Engineers Comments Regarding Surface Water Drainage

Application Reference:	F/22/26/DOC	Reviewer Reference:	ADC/EXT4b
Planning Officer:	David Easton	Date of Review:	13/04/2026
Site Name:	Land at Ford Airfield Ford		
Application Description:	Approval of details reserved by condition under F/4/20/OUT relating to conditions 28- Proposed foul drainage system, 29- Proposed surface water drainage scheme, 30- Discharges to watercourses and 31- Maintenance & management of surface water drainage system.		
Assessment Number:	1 of 2

Response	Condition 29: Objection Condition 30: Further information required Condition 31: Objection
-----------------	--

SECTION THROUGH FLOW CONTROL MANHOLE
(N.T.S)

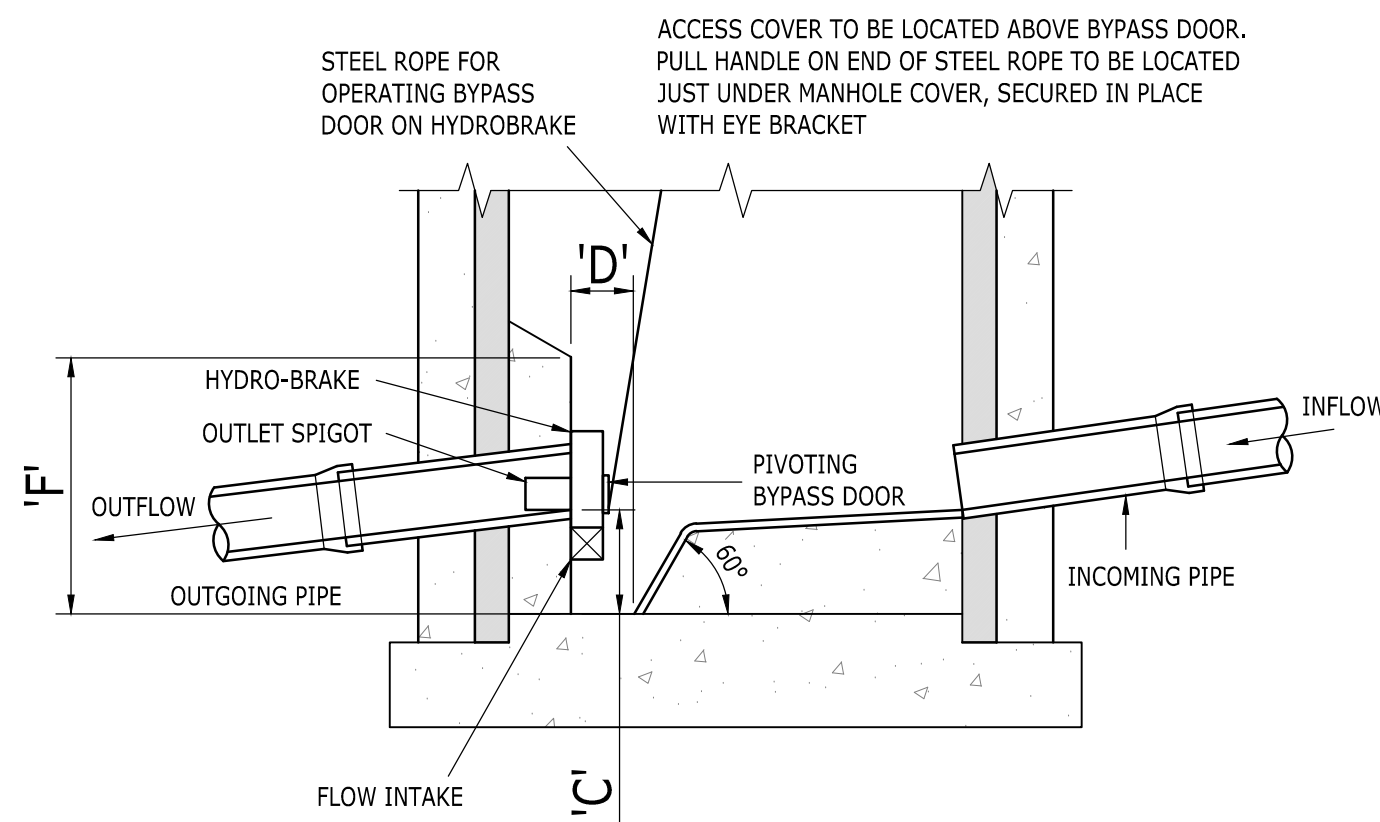
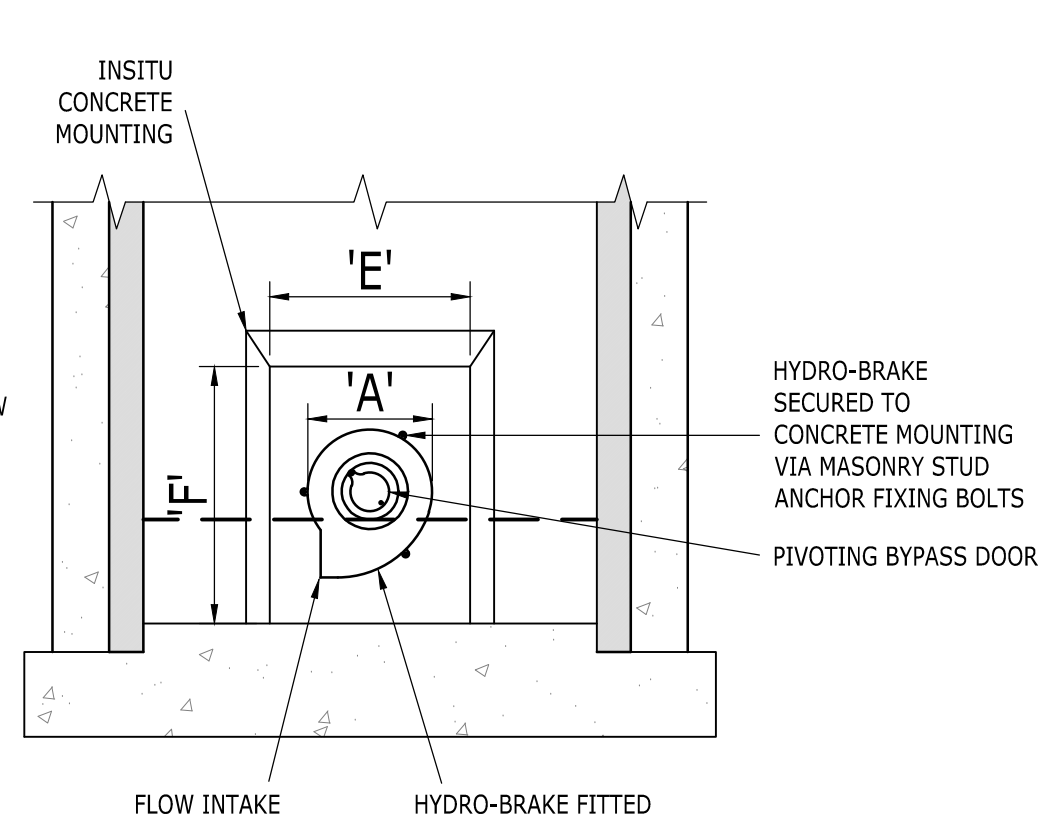
24.	Please submit surcharged outfall settings with the revised calculations.				
25.	There appear to be manholes missing from the surface water drainage schedules. Please submit schedules for all manholes.				
26.	The hydrobrake dimension table is useful, please also include the invert and cover levels plus incoming and outgoing pipe diameters on this.				
27.	Please submit a construction detail for all headwalls. Where headwalls are of a similar design an accompanying table may be used to inform the specific details for each one.				
28.	The RoSPA Desktop safety review quotes depths that do not reflect those shown in the submitted calculations and plans. Please get the report adjusted to suit the updated modelling. (For example, north basin 1 is quoted as being 2.1m in overall depth and a
